Permit Number 021712

This is to certify that Add bedroom and bathroom addition to existing home.

Re: House addition drawings for Raymond Eastman permit application

FOUNDATION AND FLOOR FRAMING PLAN
 Scale: 1/2" = 1'-0"

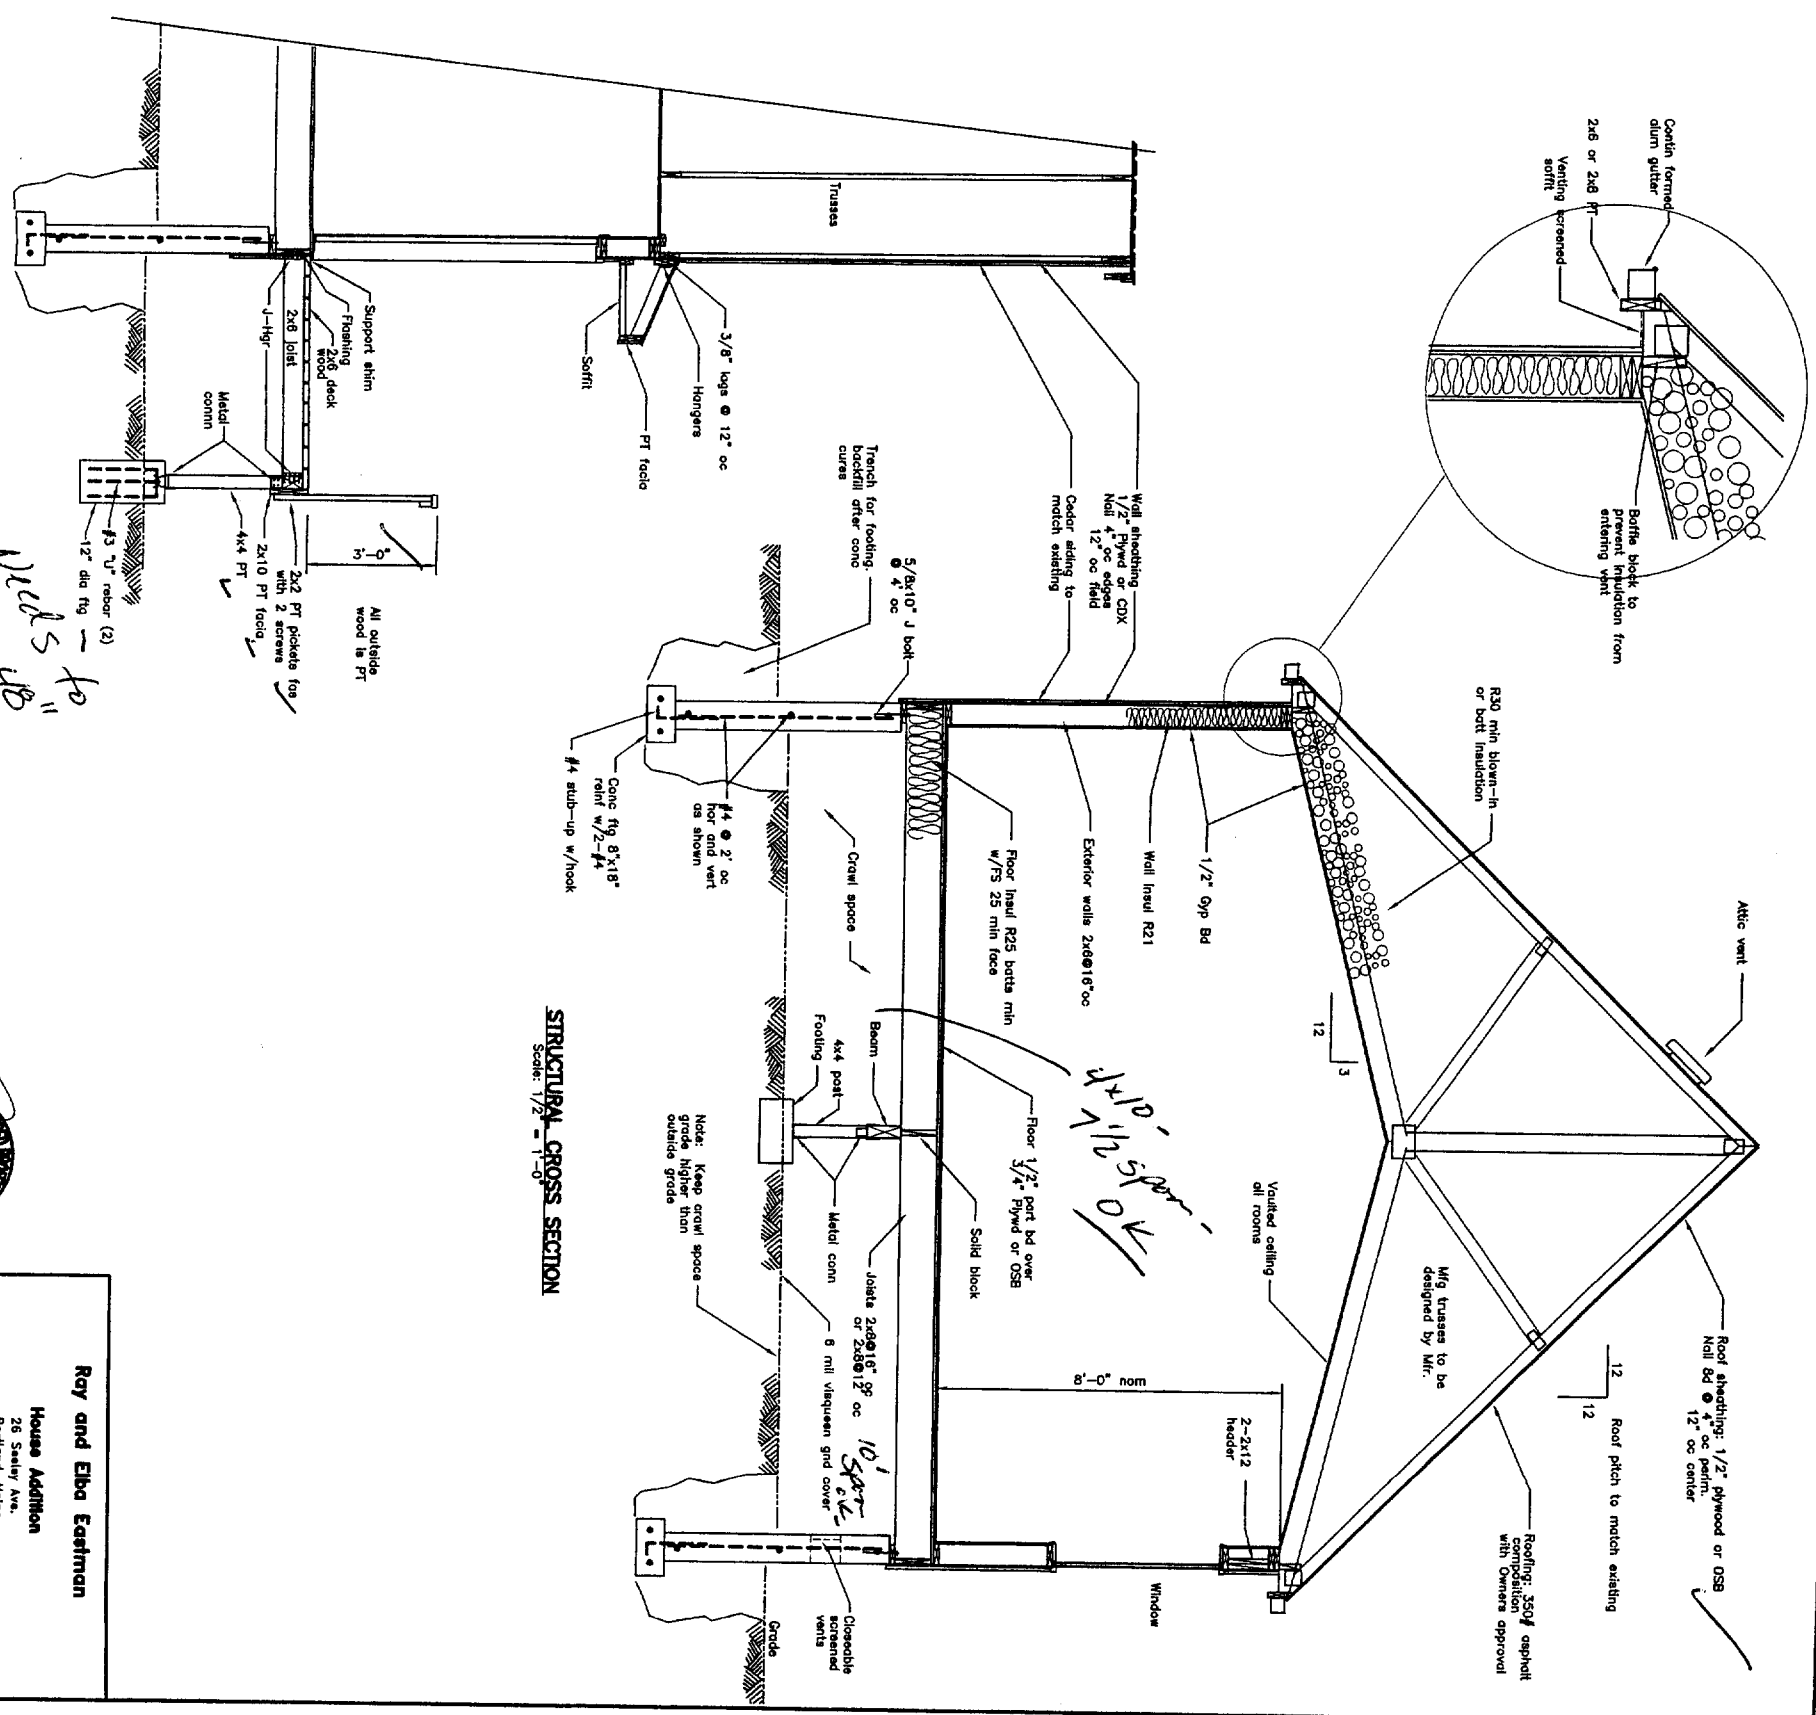
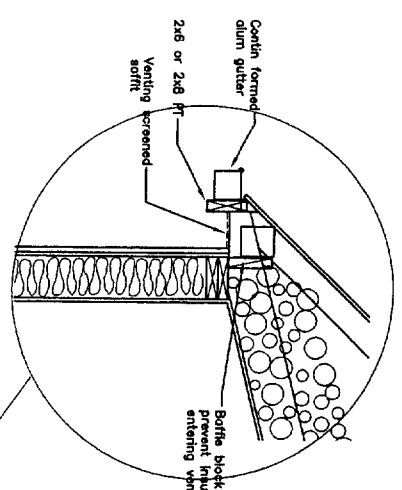
12/29/04-trmm: Need to add smoke det, safety galss near whirlpool, footings need to be 48" and frost walll, went over crawl space and attic access sizes, need header schedule, and went over t/r req for step to whirlpool. Went over all w/owner - will submit more info.

- ✓1. Install a smoke detector per code in the proposed bedroom wired to another smoke detector (existing or new) in the existing first floor of the house.
- ✓2. Windows in bathroom near the bathtub to be tempered glass.
- ✓3. Deck footings to extend to 4 ft below finish grade.
- ✓4. New foundation footings to be 4 ft below finish grade.
- ✓5. Crawl space access to be 18"x24" min.
- ✓6. Attic access to be 22x30" min.
- ✓7. Exterior window and door headers are 2-2x12.
- ✓8. A step to the whirlpool tub to have 10" min. tread, 7.75" min rise.
